Rezoning Transportation Analysis

Petition Number: 2023-089

Date	Description
9-28-23	Review (IW)
12-19-23	Second Review (KC)
01-24-24	Third Review (KC)

RZ-1.0

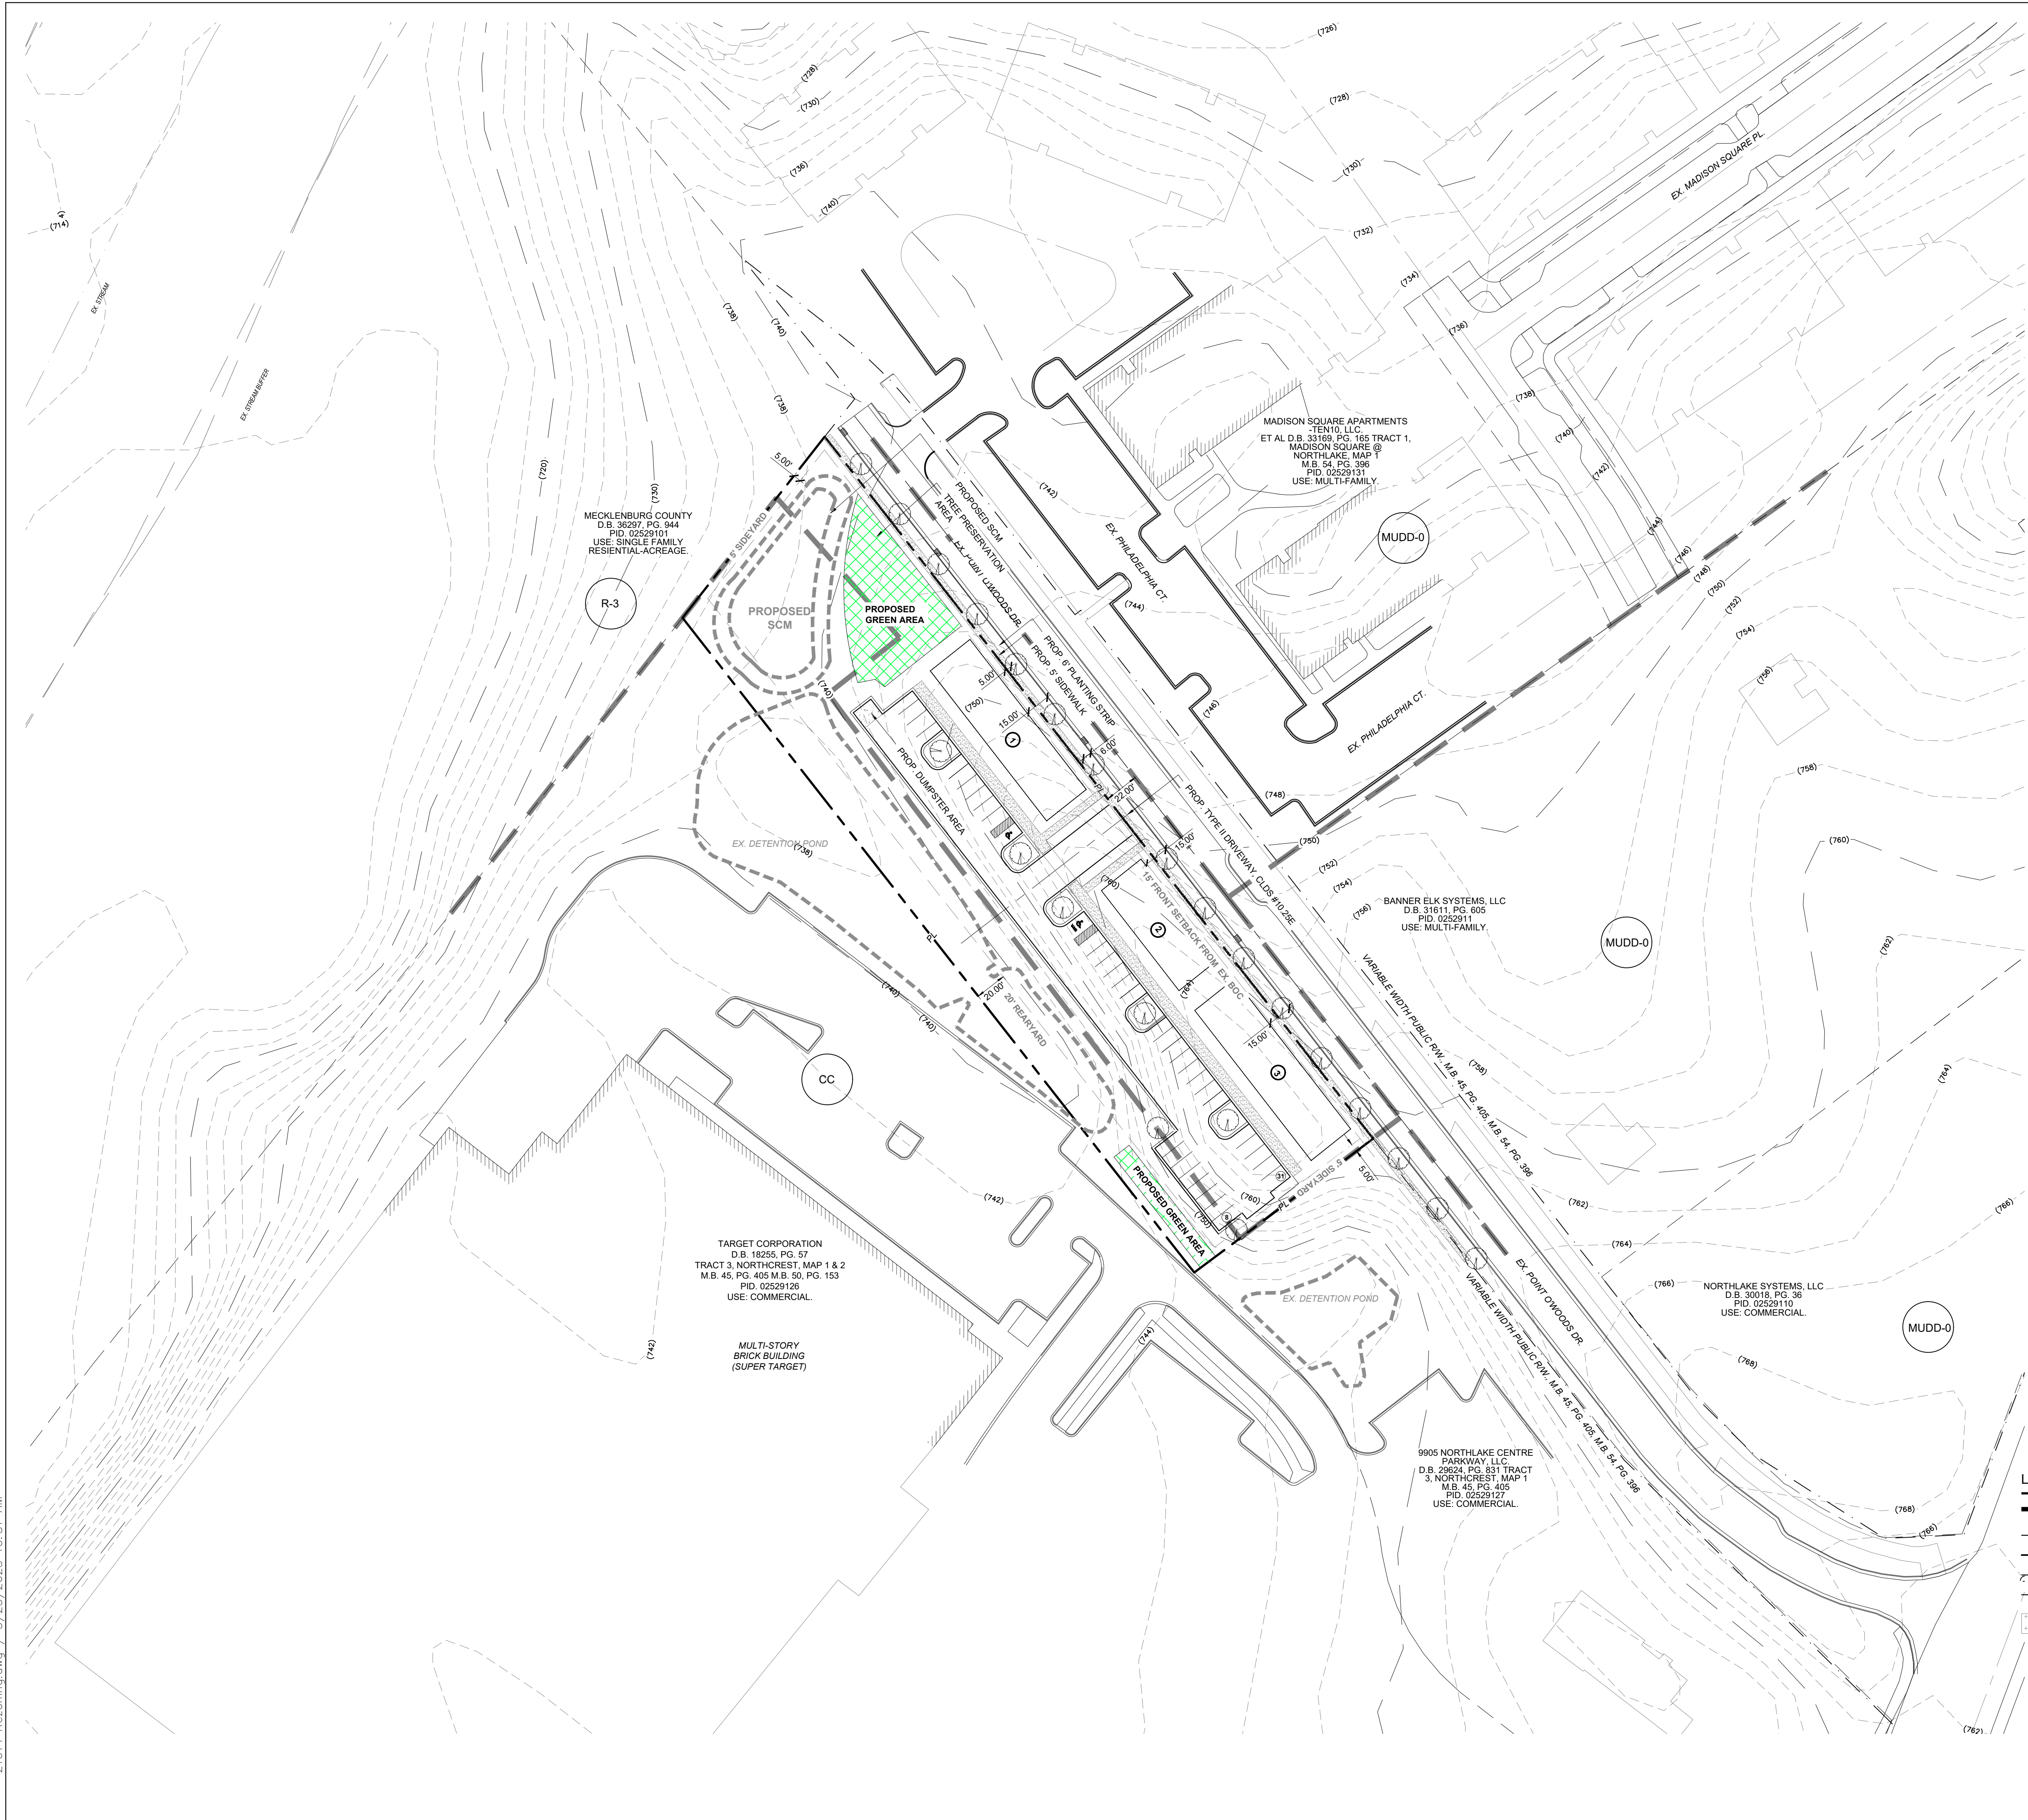
a. ~~**Point O' Woods Drive:** The future location of curb and gutter is in its existing location.~~

~~CLDSM Local Residential Medium Street U-02B~~

~~Label and dimension the curb and gutter from the centerline for each road on the site plan.~~

~~3. Revise site plan and conditional note(s) to commit to dedicate 27 feet of right-of-way from the road centerline. The site plan shall label and dimension the right-of-way from the road centerline.~~

~~5. Revise site plan and conditional note(s) to commit to installing an 8' Planting Strip and 8' Sidewalk based on Article 33 in the UDO for Neighborhood 2 Place Type.~~

~~6. Revise conditional note 5.d. to commit to an 8' Planting Strip and 8' Sidewalk instead of the 6' Planting strip and 5' sidewalk stated in the note.~~
